Date: 04-Aug-2021
Our Ref: 2018/92802

**Application for Approval of Details Reserved by Condition
Town and Country Planning Act 1990
Planning (Listed Buildings and Conservation Areas) Act 1990**

**Discharge of condition 17 (electric vehicle charging) of previous permission
2015/93824 for outline application for erection of 56 dwellings and care home with
associated car parking
Former Midlothian Garage, New Mill Road, Holmfirth, HD9 7LN
Application Number: 2018/92802**

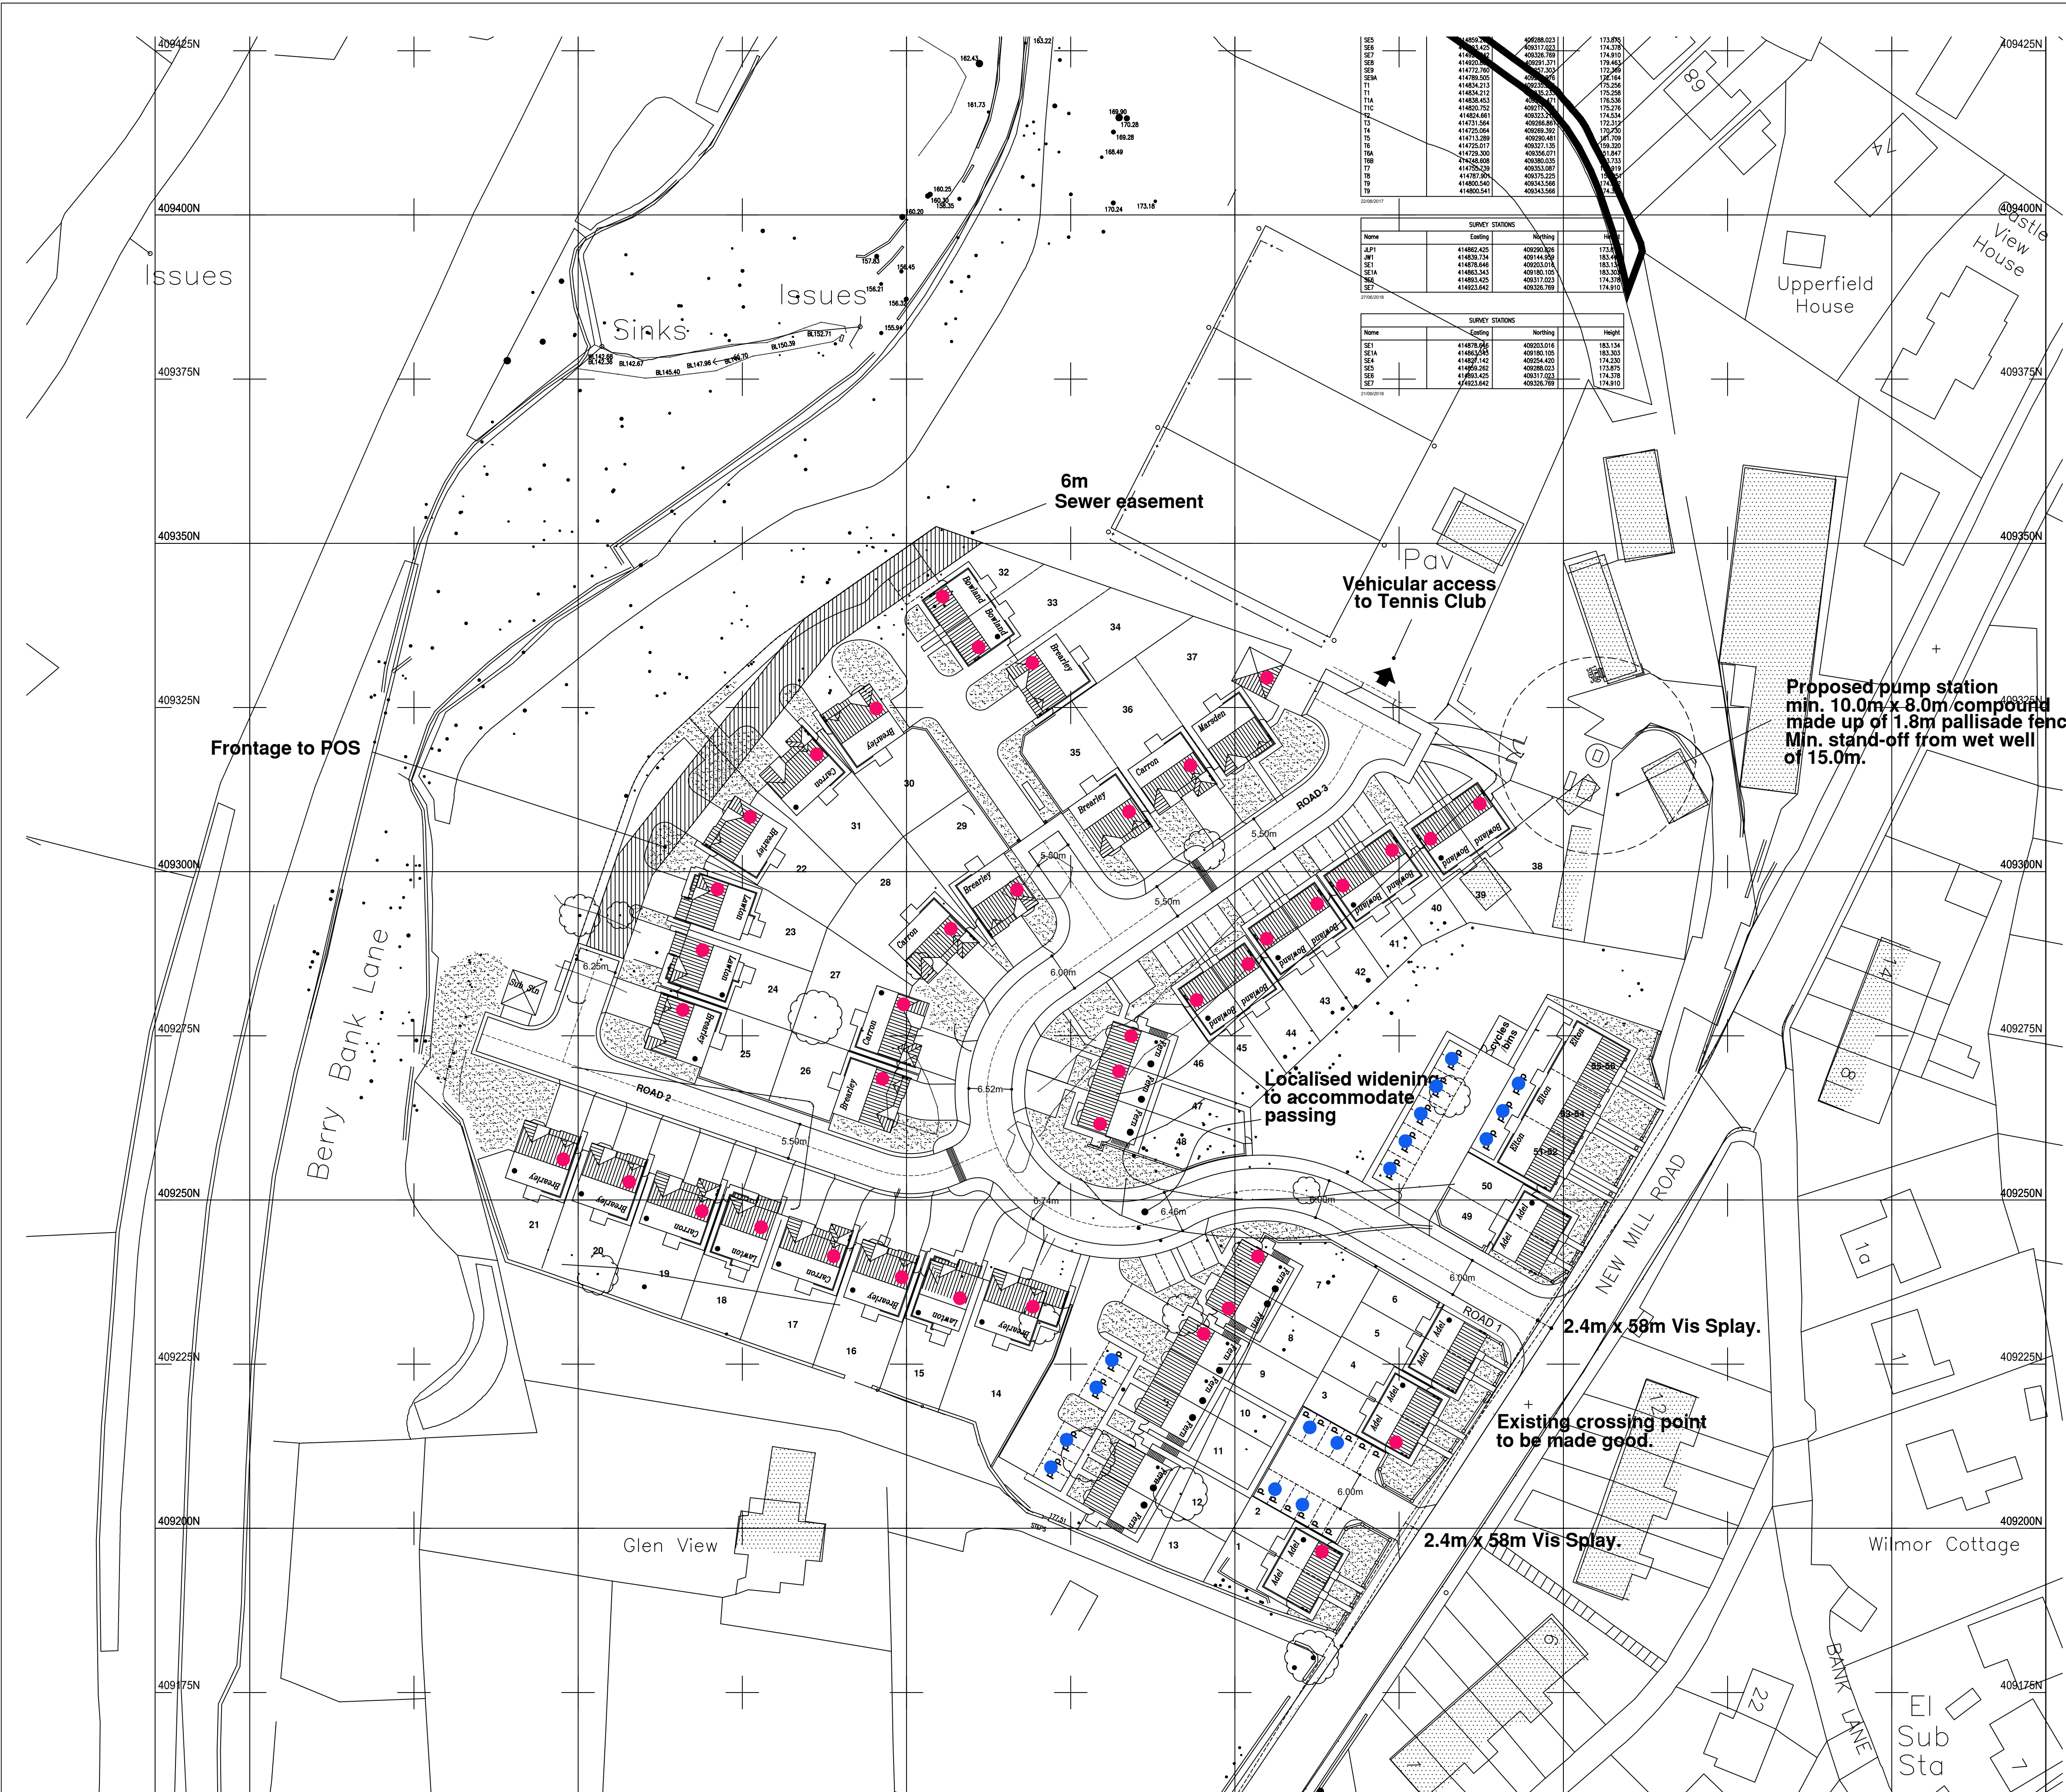
The submitted information advises that an electric vehicle charging point will be provided to every property and that these will be supplied by a 16A fused spur. All of the plots with parking within the curtilage will have a Mode 3 charger and plots with detached parking will have a Mode 3 charger. The charger information provided shows the Mode 2 charger which has a 13A socket outlet.

The provision of a charger to each property meets the scale of provision that is required by this Authority. However, Mode 2 chargers are not considered to be acceptable, particularly when they have only a 13A socket outlet. This is insufficient to fully charge a typical electric vehicle within a reasonable time scale. Also, details of the socket outlet for the proposed Mode 3 chargers are not provided.

The proposals are therefore insufficient to meet the requirements of condition 17 and the condition is not discharged.

An acceptable standard would be a charging point for every plot that provides at least Mode 3 charging with a Type 2 socket outlet capable of providing a continuous supply of 16A and a maximum supply of 32A.
